Development Facilitation Team (DFT) – Review Comments

DRB Project No: PR-2019-002874 Date: 02/07/2024 Agenda Item: #12 Zone Atlas Page: B-13

Application For: SD-2024-00024- PRELIMINARY/FINAL PLAT (DFT)

DRB Project Number: 2019-002874 Hearing Date: 02-07-2024
Project: Tracts C-1 & C-2, Cottonwood
Pointe Subdivision Agenda Item No: 12

**Exhibit B
Existing Eagle Ranch
Road with
3' Buffer**

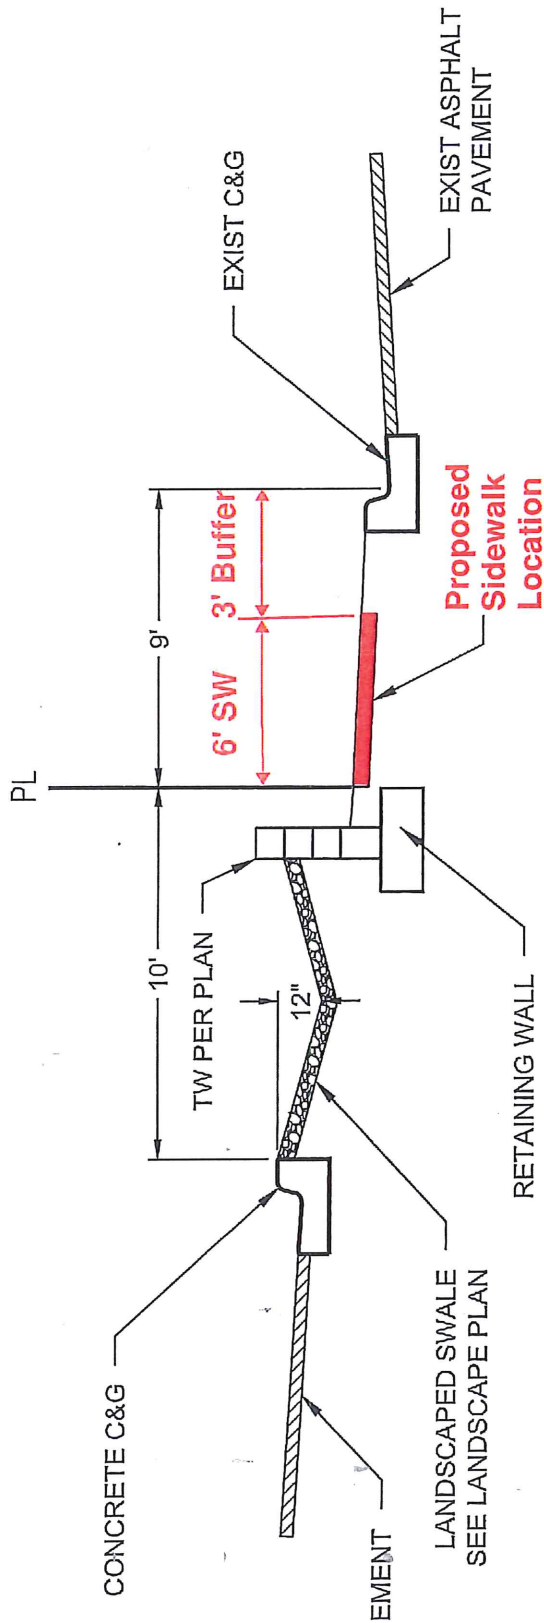
1. Both Irving and Eagle Ranch are Arterials and require 6' sidewalk with 5' to 6' landscape buffer. You have proposed to build 6' sidewalk along both roadways, but the landscape buffer shown does not meet the required width. Please provide 5' to 6' landscape buffer or request a waiver to allow a smaller buffer.
2. For future development an approved Traffic Circulation Layout (TCL) will be required prior to site plan.

****Verification of standards per Transportation****
Both Irving and Eagle Ranch are Arterials and require 6' sidewalk with 5' to 6' landscape buffer. You have proposed to build 6' sidewalk along both roadways, but the landscape buffer shown does not meet the required width. Please provide 5' to 6' landscape buffer or request a Determination to allow a smaller buffer.
